REVISION/DEFERRED SUBMITTAL FORM

Revision Log

Permit: #2012-200

Project Address: 3310 97th Ave SE, Mercer Island, WA 98040

1 LOWER LEVEL REFLECTED CEILING PLAN
1/4" = 1'-0"

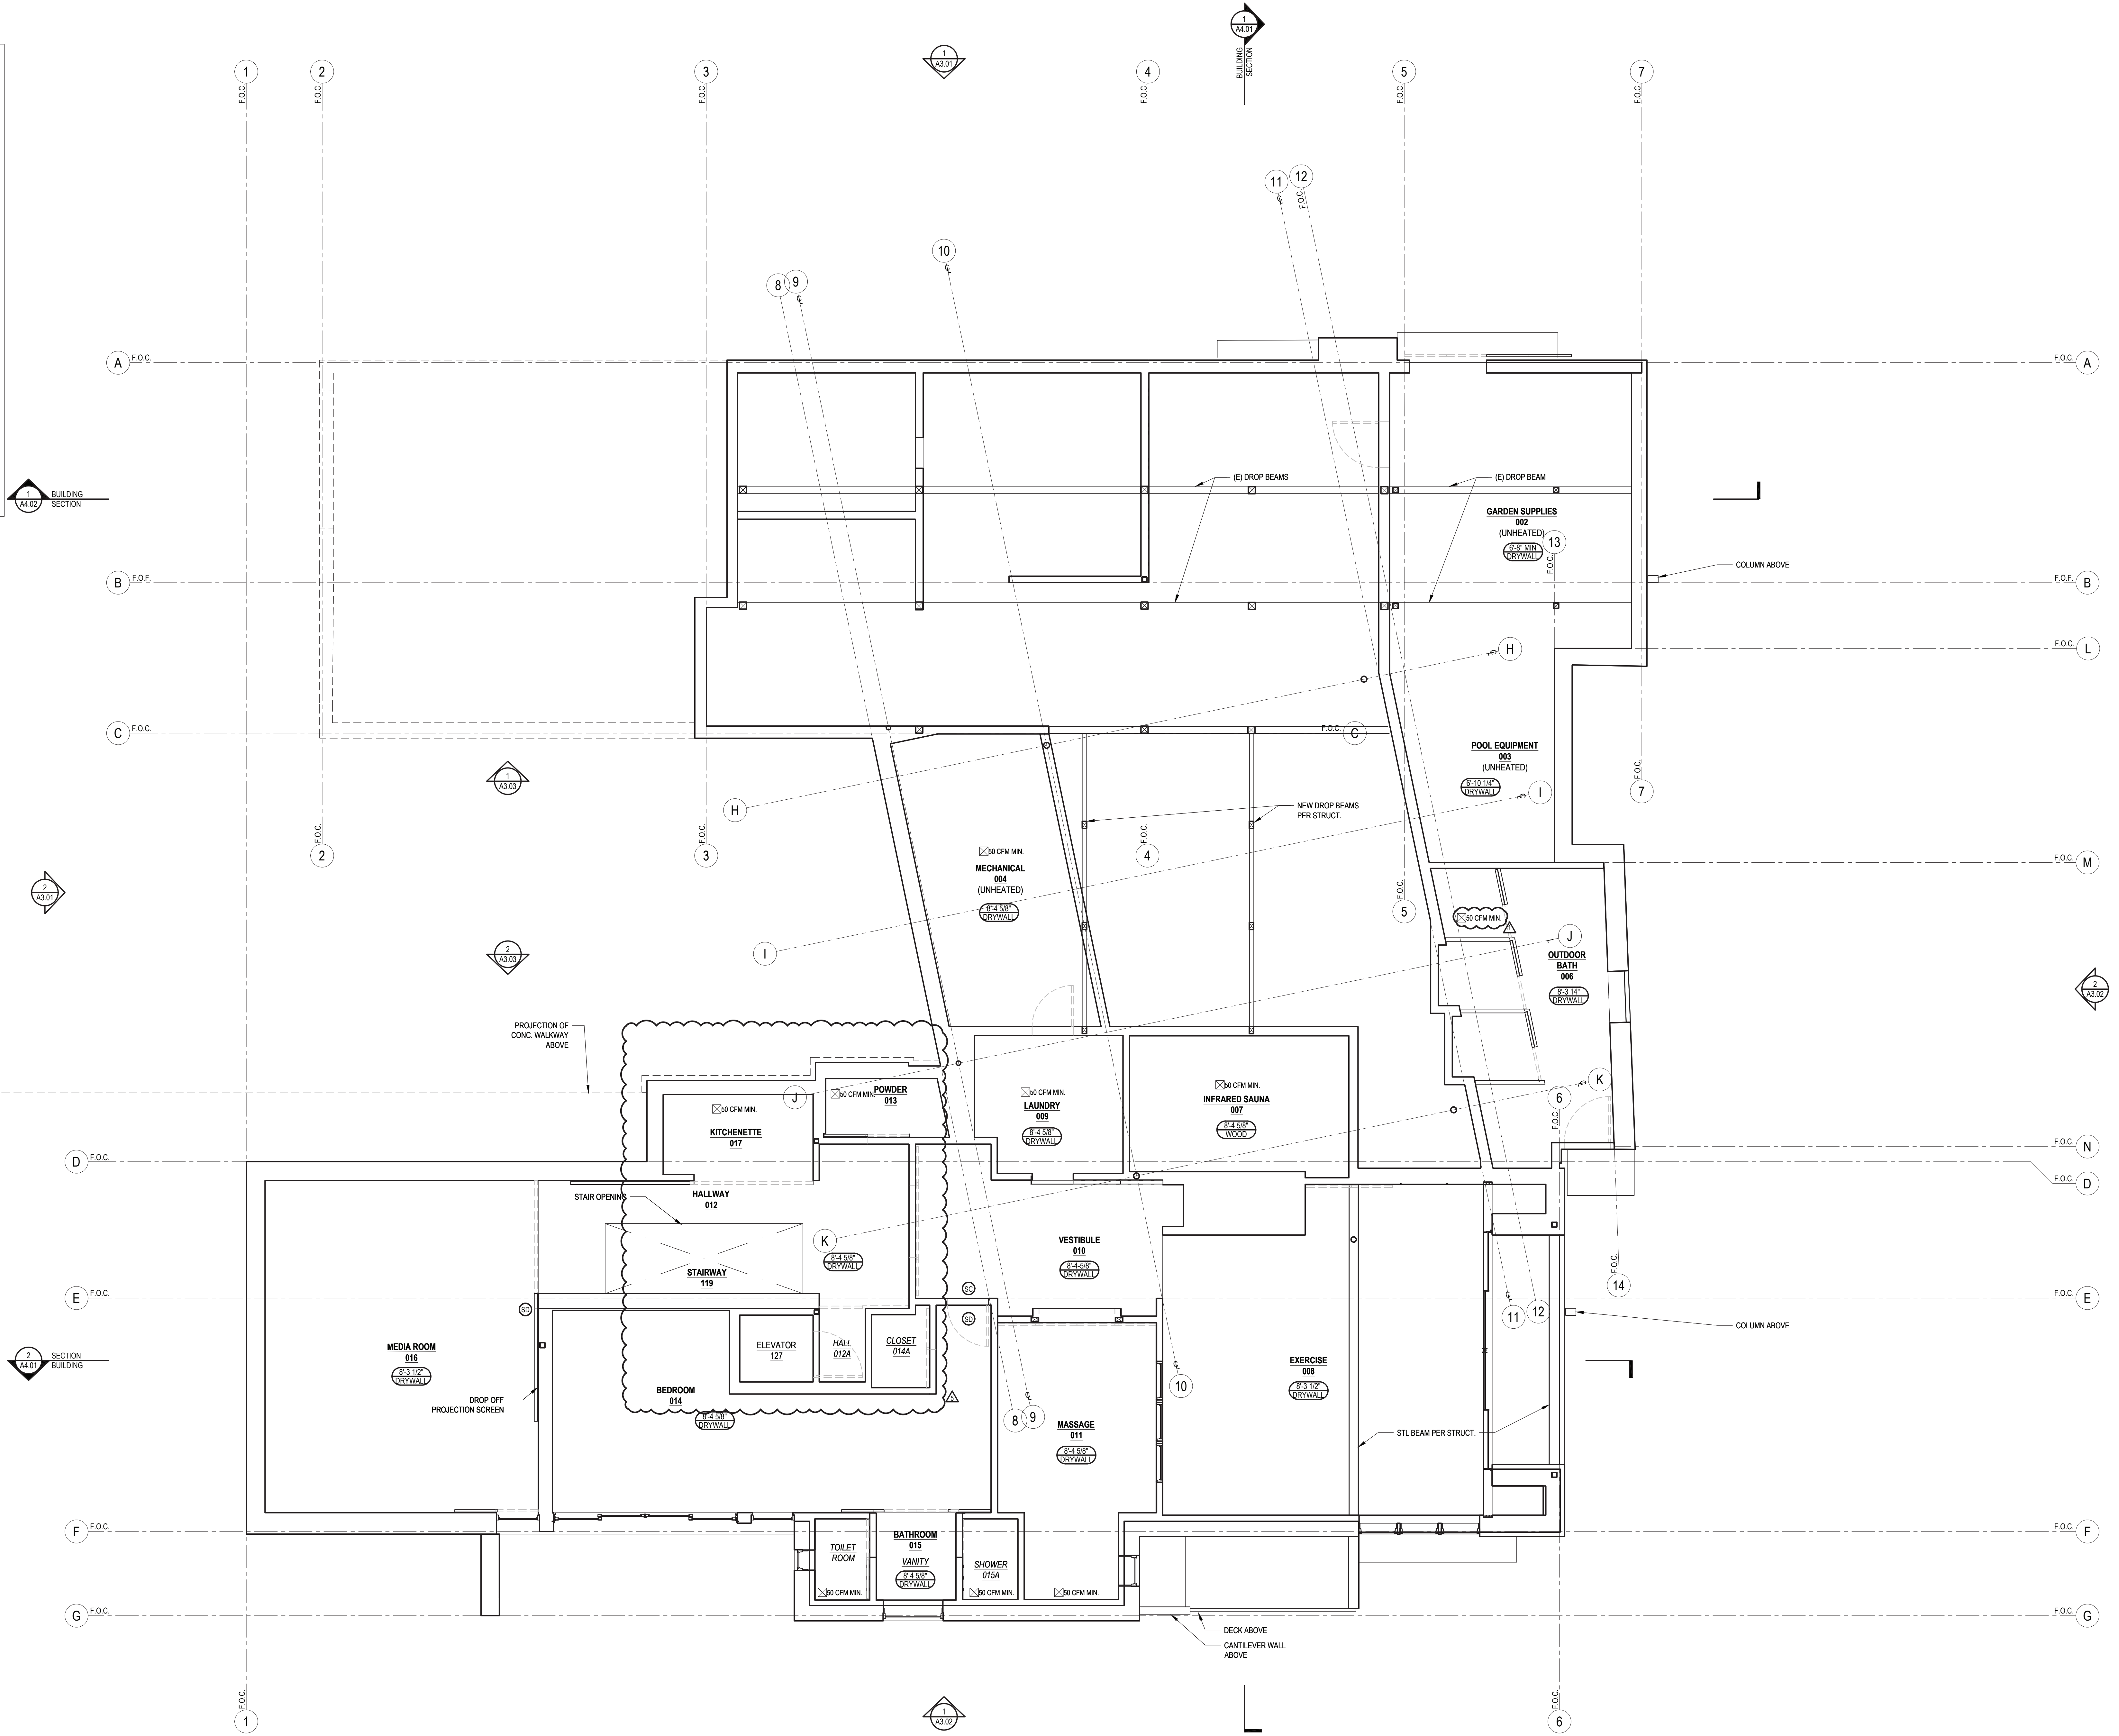
- Revised the reflected ceiling plan for newly added ELEVATOR 127 and HALL 012A
- Relocated POWDER 013, CLOSET 014A and KITCHENETTE 017

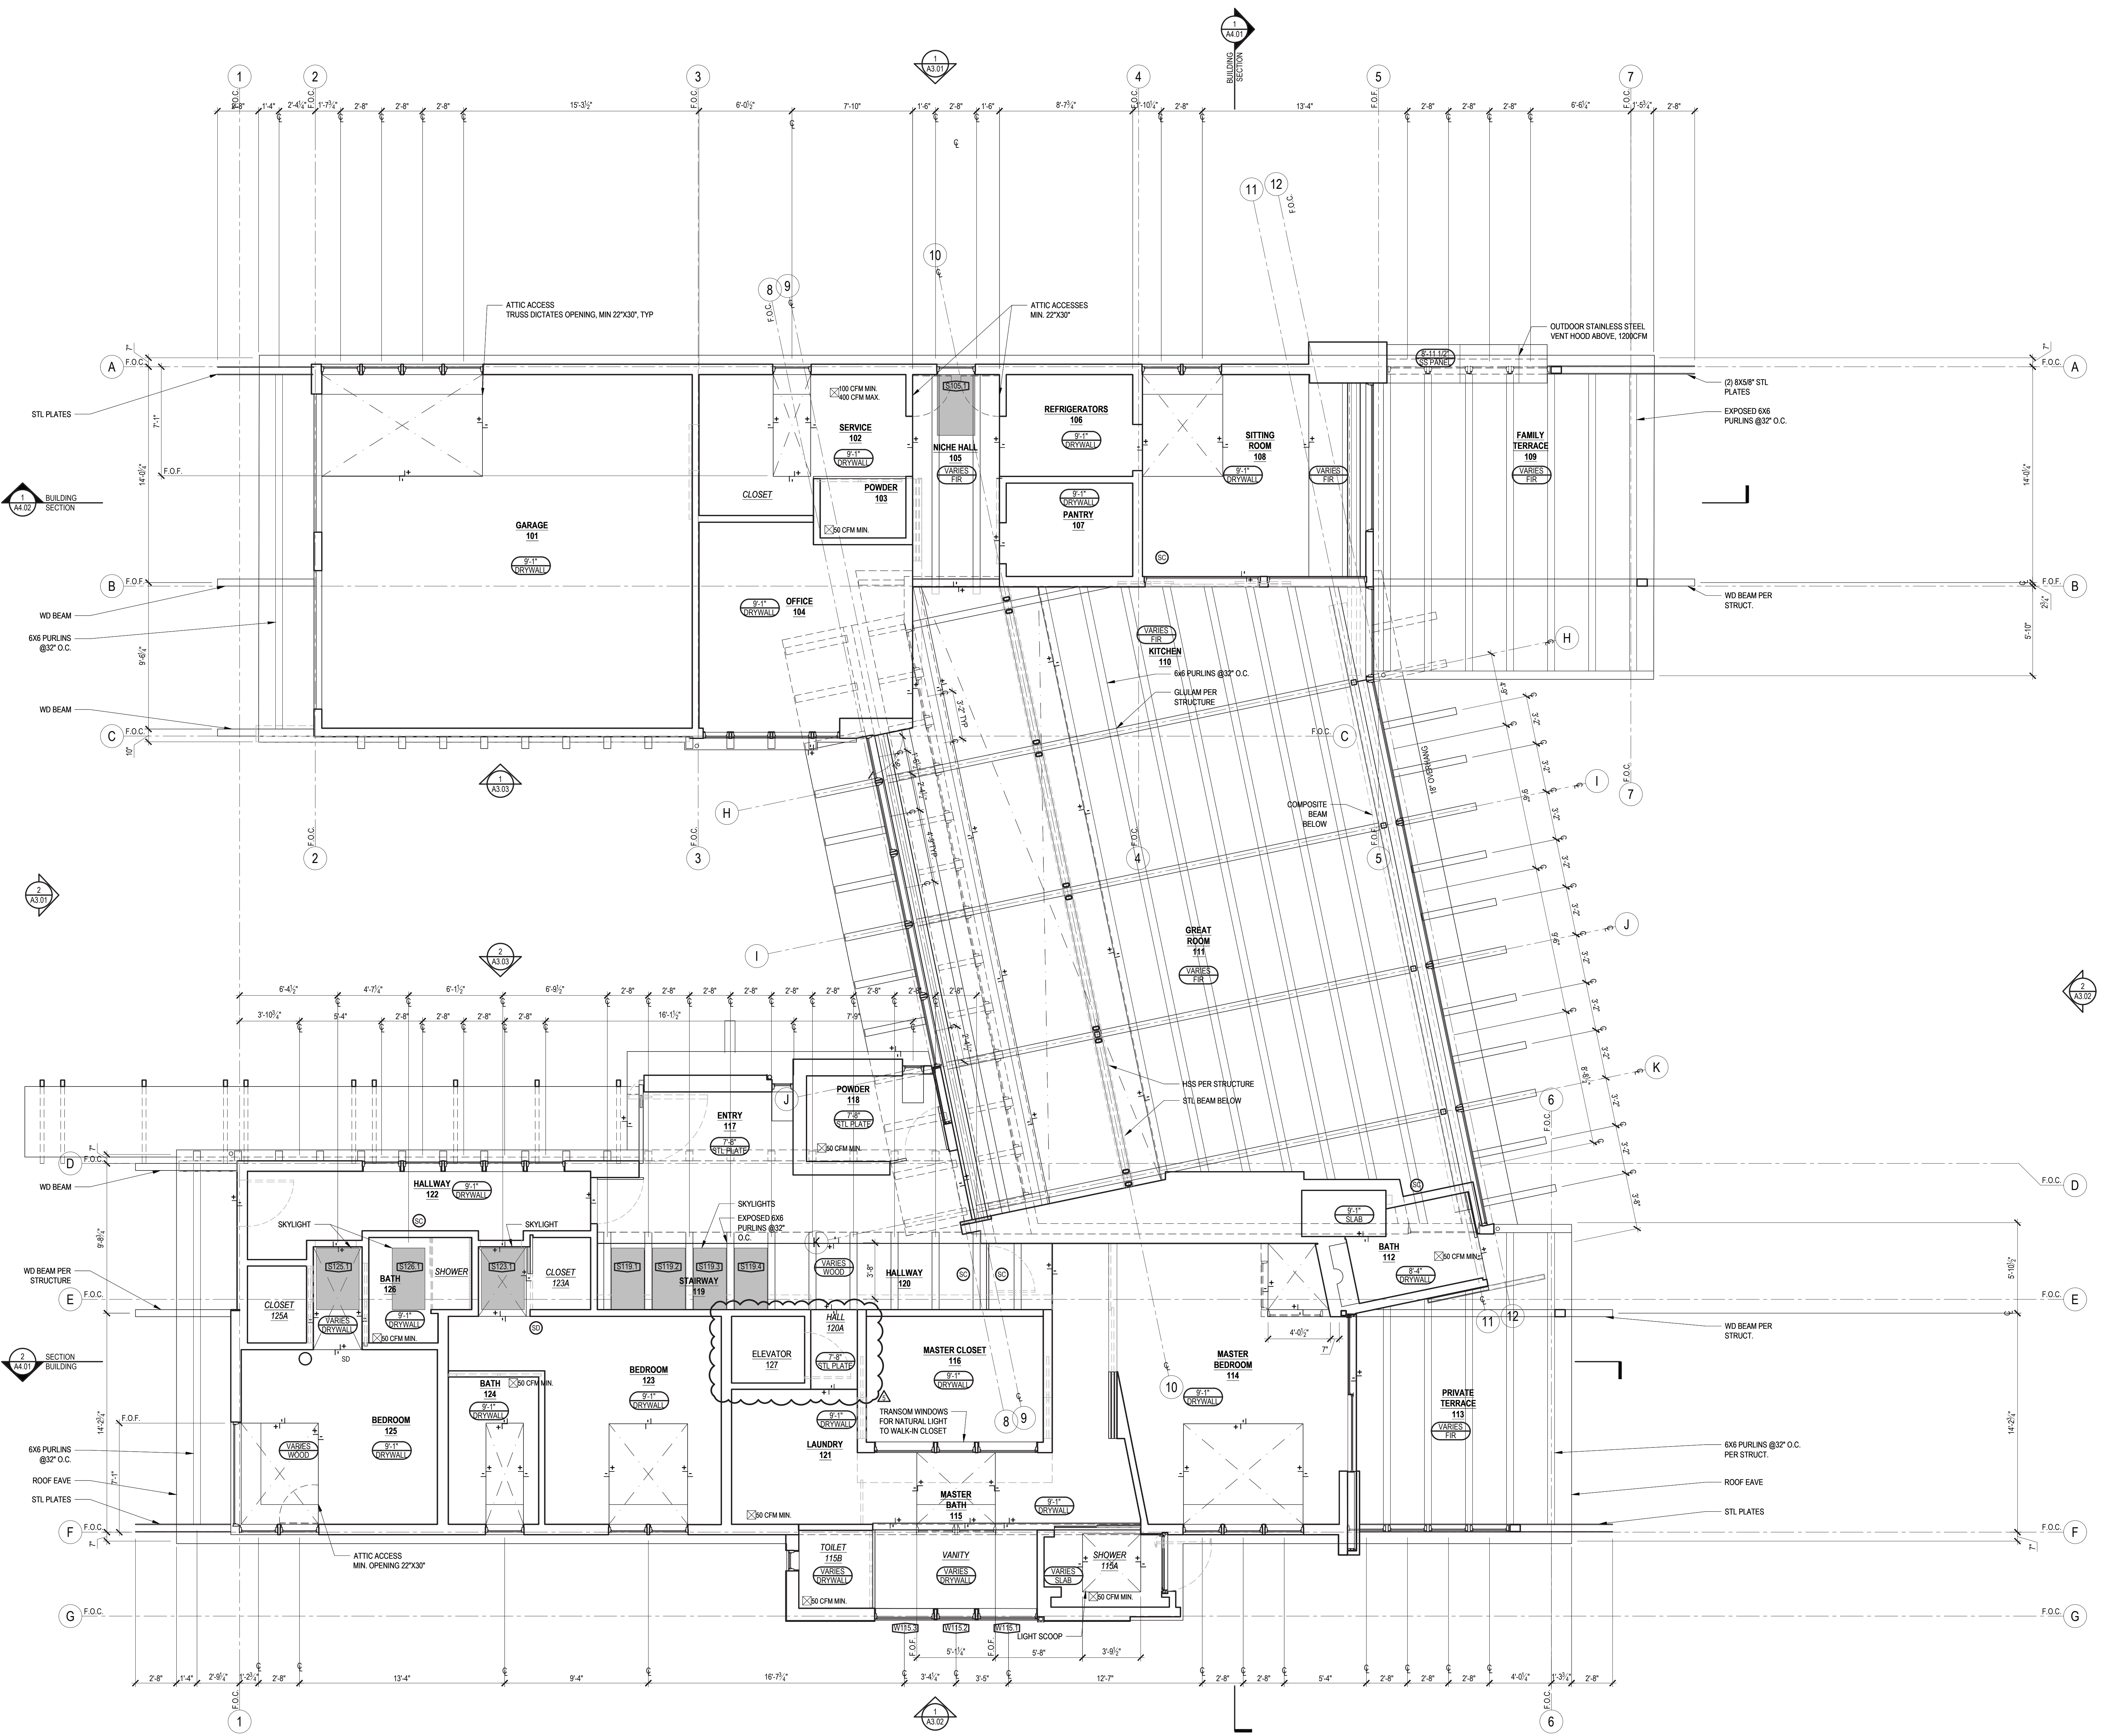
- Revised the ceiling plan around newly added ELEVATOR 127 and Hall 120A

S2.0

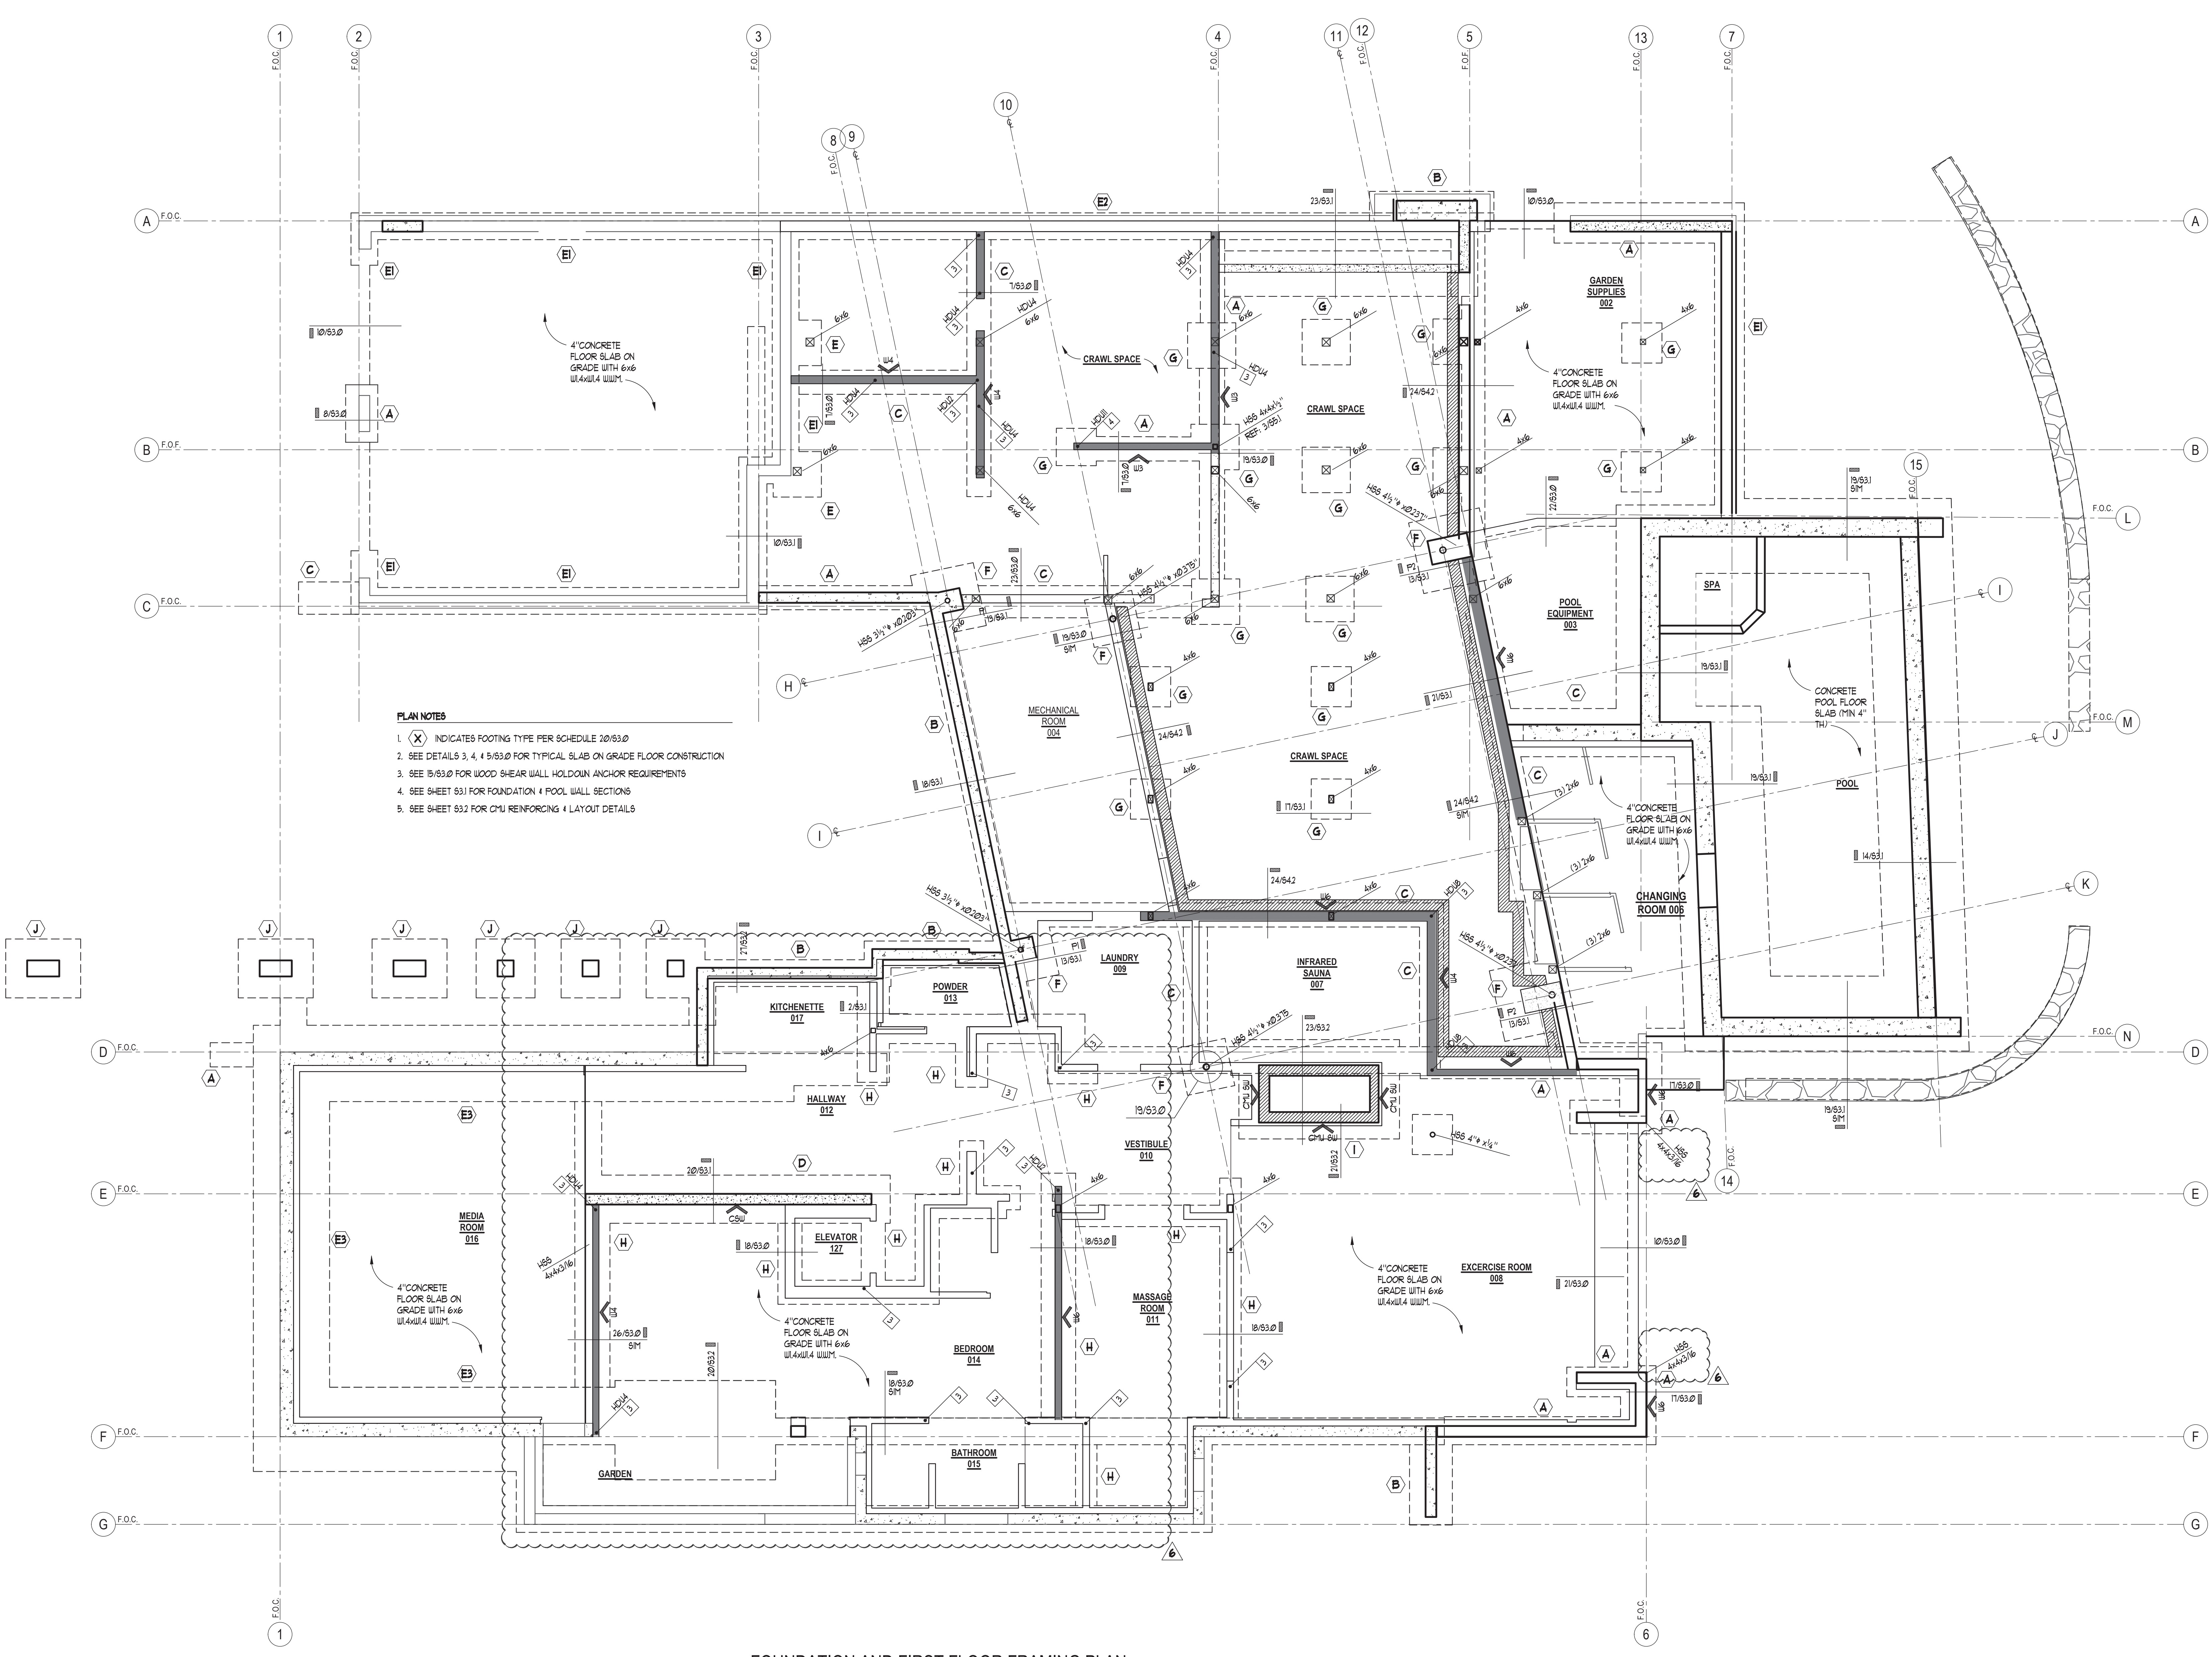
- S2.0 – Foundations and wall layouts revised for planning changes and new elevator in east wing
- S2.1 – Walls updated for new bathroom and entry layouts to accommodate new elevator. Framing revised to accommodate updated floor assemblies with flush finishes at bathrooms and terrace areas.
